NKDC submissions at Deadline 3 include our Oral Submission Summaries and responses to the ExA's Action Points from ISH2, 3 and 4.

## Springwell Solar Farm – Written Submission of Oral Case to ISH2 from North Kesteven District Council (ID 20054501)

## Springwell Solar Farm – Written Submission of Oral case to ISH3 from North Kesteven District Council (ID 20054501)

## Springwell Solar Farm – Written Submission of Oral case to ISH4 from North Kesteven District Council (ID 20054501)

DOCUMENT:
ENVIRONMENTAL STATEMENT
VOLUME 2: FIGURES
REGULATION 5(2)(a) & 5(2)(l)(ii)

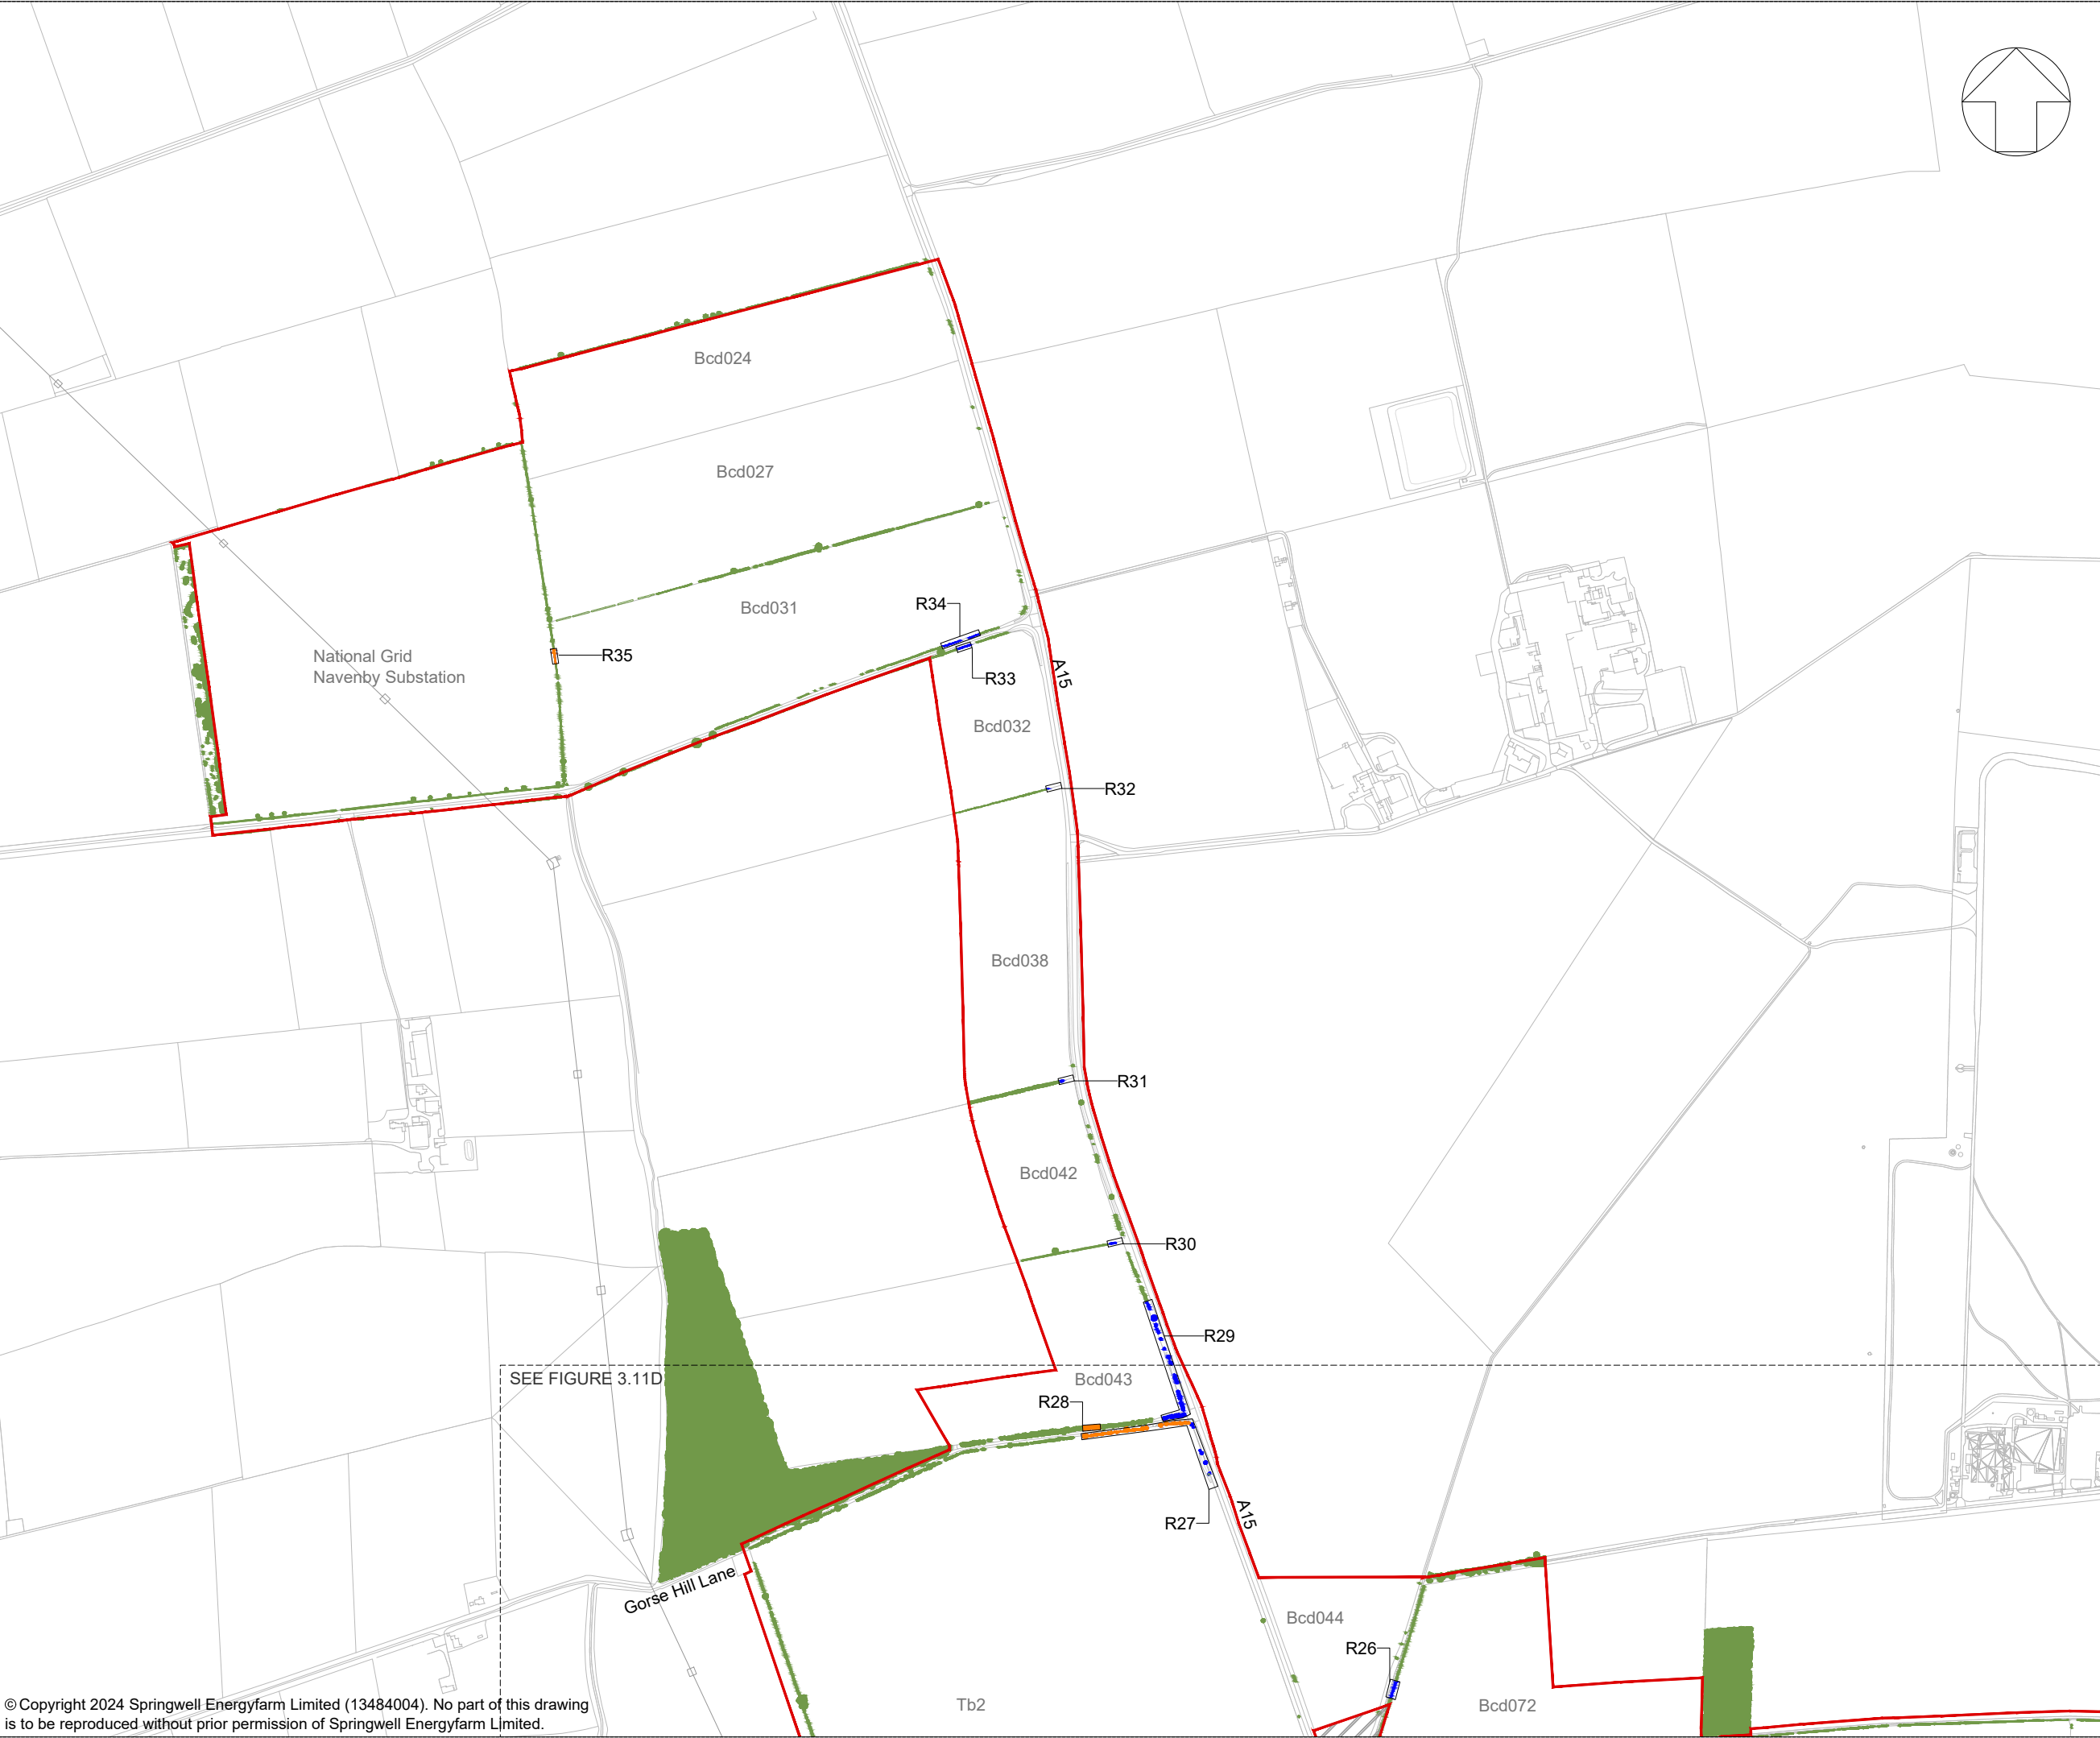
conservative estimate, this would equate to over 350,000 panels generating up to 200MW in Springwell East alone, which would still be classed as a very large scale solar scheme and well above the current threshold to be considered an NSIP.
<b>3.3 The Applicant will be asked questions relating to the vegetation removal parameters (Figures 3.11A to 3.11F) [REP1-027] and how landscape and visual impacts will be accounted for in finalising the location of vegetation removal.</b>	n/a
<b>Visual Impact and Design</b>  <b>3.4 The Applicant will be asked about the design process that is secured in the draft Development Consent Order and control documents.</b>	n/a
<b>3.5 North Kesteven District Council will be asked to expand on its concerns relating to the visual impact of highways components.</b>	<p><b>Submissions made by Oliver Brown, AAH Consultants on behalf of NKDC</b></p> <p>Under <b>Agenda Item 3.5</b>, in regard to concerns relating to the visual impact of highways components, localised removal of vegetation is identified in the assessment of landscape effects; however, at the time of writing our LVIA review it was unclear whether this included vegetation works on the wider highways network, and what this would entail. We have subsequently discussed this with the applicant at a recent meeting prior to the hearing, and they have now clarified the vegetation loss in the wider landscape, which takes account of anticipated highways and construction works including internal tracks, cable routes and the grid connection corridors. The location of vegetation removal is indicated by the Vegetation Removal Parameters</p>

<p>presented in Appendix 2 of the oLEMP [REP1-064] and these same figures are included as Figures 3.11A-3.11F of ES Volume 2, Figures, Chapter 3 [REP1-027].</p> <p>Should the DCO be granted consent, detailed LEMP(s) will be produced for the Proposed Development in accordance with the DCO Requirement in Schedule 2 of the draft DCO [REP1-006]. The LEMP(s) would require approval by the relevant planning authority prior to commencement of construction and would be required to be substantially in accordance with the framework set out in the OLEMP [REP1-064], including the Green Infrastructure Parameters presented in Appendix 1 and Vegetation Removal Parameters presented in Appendix 2.</p>
<b>3.6 The Applicant will be asked questions relating to the impact of glint and glare prior to Year 10 of operation and the visual impact of any temporary mitigation prior to the establishment of screening planting.</b>	n/a
